**KIRKLEES METROPOLITAN COUNCIL
INVESTMENT & REGENERATION SERVICE**

DELEGATED DECISION TO DETERMINE PLANNING APPLICATIONS

Reference No:	2024/62/93033/E
Site Address:	9, Beckett Crescent, Dewsbury Moor, Dewsbury, WF13 3PW
Description:	Erection of part two storey and part single storey rear extension and single storey side extension
Recommending Officer:	Faiza Bano

HOUSEHOLDER DELEGATED REPORT

PROPOSED GROUND FLOOR PLAN

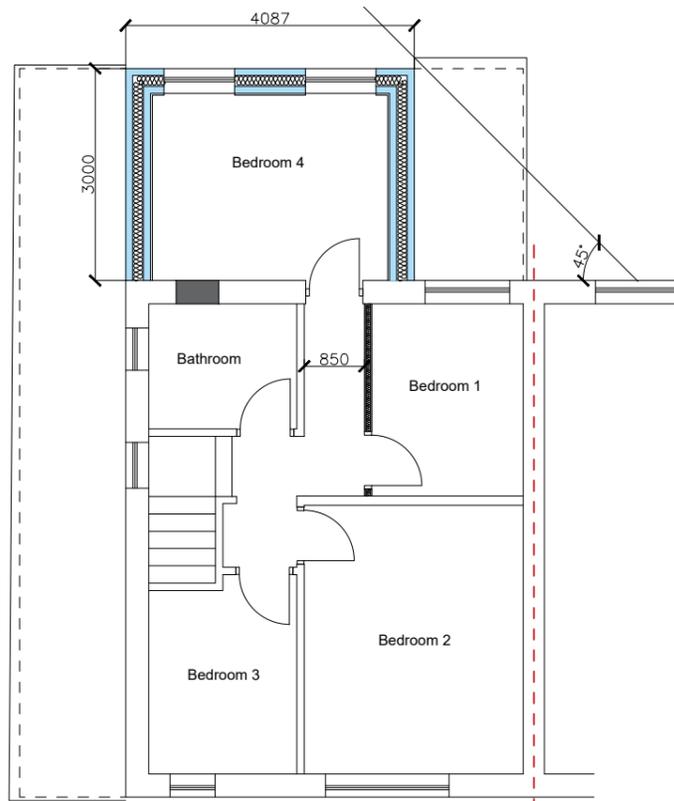
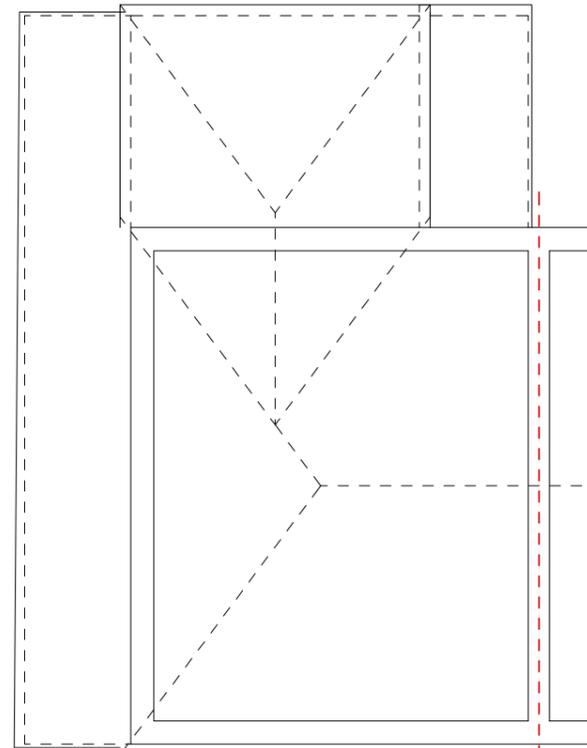
Updated internal arrangement plans have been submitted by the agent because the current plans do not meet the policy requirements for a bedroom. The outlook is severely compromised by the extension. This update addresses the outstanding concerns, as the room is now designated for storage and will not be used as a bedroom, thereby avoiding any detriment to the amenity of future occupants. This change ensures compliance with policy requirements.
